OBSERVATION/SUBMISSION TO PLANNING APPLICATION

Case Reference: 324113

Re: Observation to the proposed development of open-cycle gas turbine (OCGT) and generator with ancillary equipment.

Location: Pollnagroagh and Rathmorrissy (Townlands), Athenry, Co. Galway

Purpose		PLANNING			
Title		SITE ACCESS SIGHTLINES			
Original Scale	Design/Drawn	Checked	Authorised		
SHOWN at A1	PS	ND	AJB		
Date	Date	Date	Date		
01.12.25	01.12.25	01.12.25	01.12.25		
Status	Drawing Number	Rev			
A2	PEK3-ATK-ZZ-01-DR-CE-901200	0

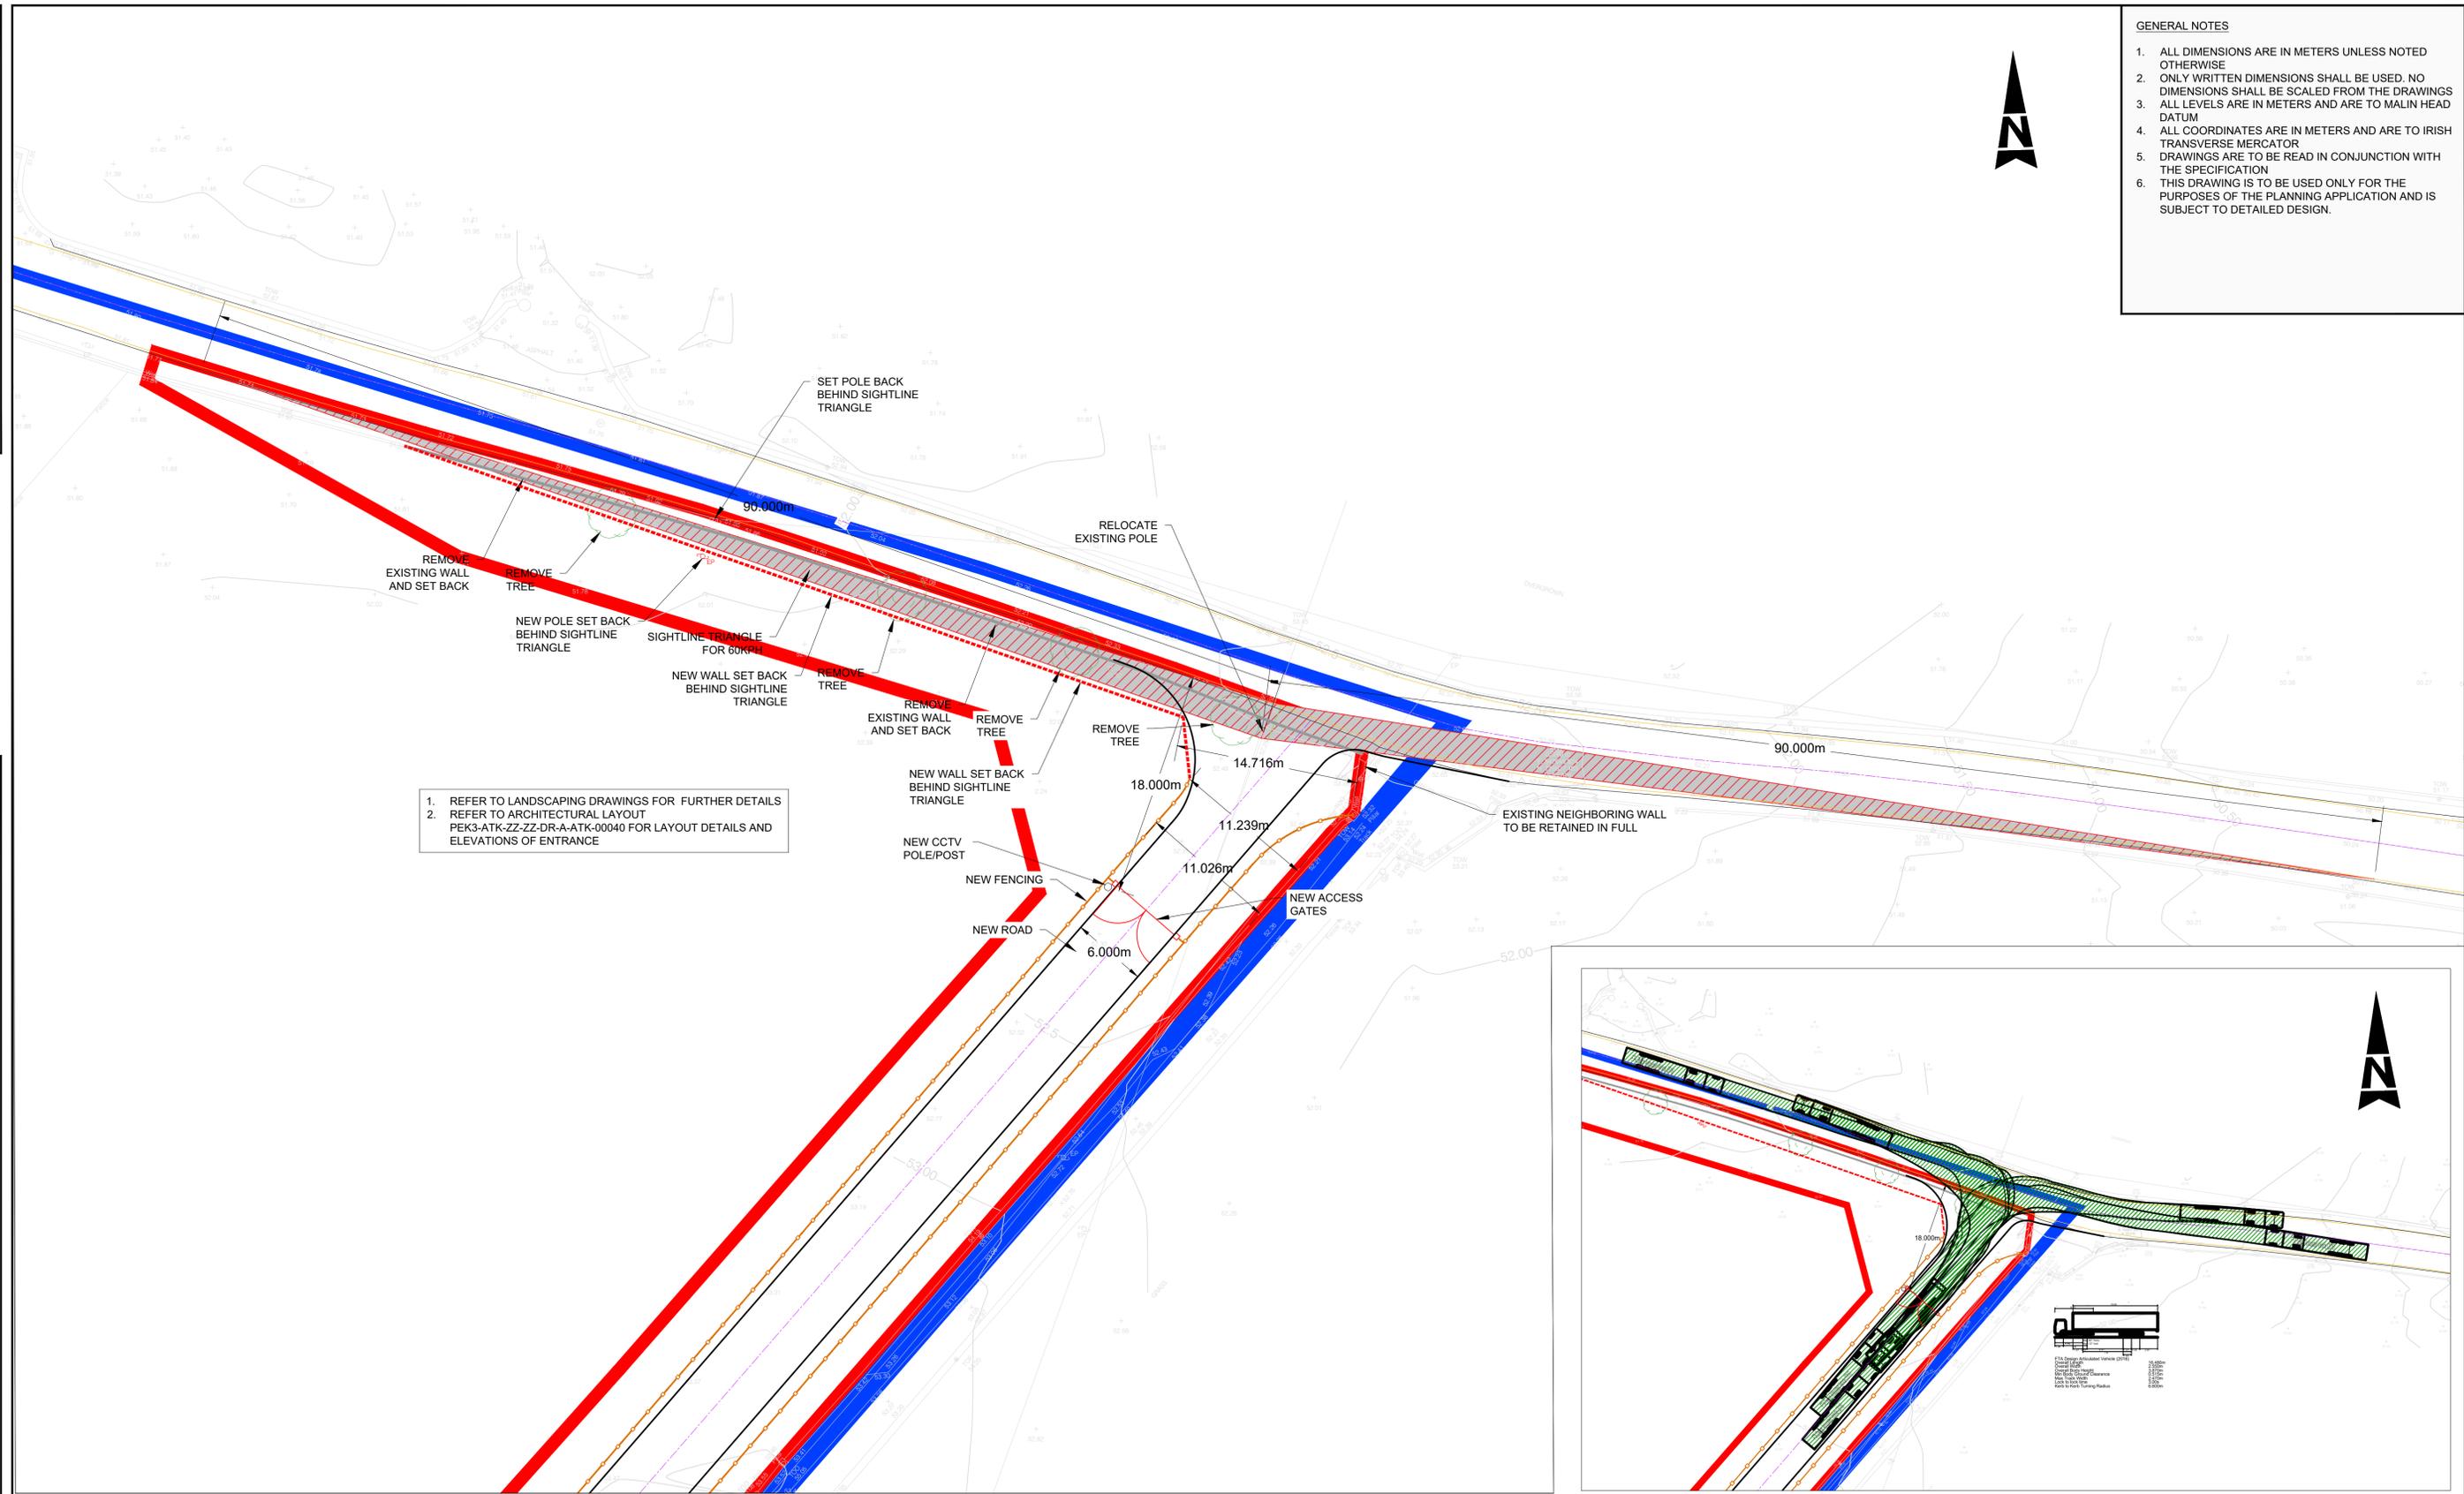
The placement of a site entrance at this hazardous location on the L3103 introduces significant and clearly identifiable safety risks, including restricted road width, lack of a hard shoulder, and severely limited visibility due to blind dips and corners. Despite these known constraints, the Environmental Impact Assessment does not adequately assess the safety implications of this access point.

The cumulative impact of construction traffic, operational traffic, and fuel deliveries has not been fully assessed. This includes the interaction of heavy goods vehicles with existing rural traffic, school-related movements, and agricultural use. The absence of a detailed and robust traffic safety assessment creates uncertainty regarding whether the local road network can safely accommodate the proposed development.
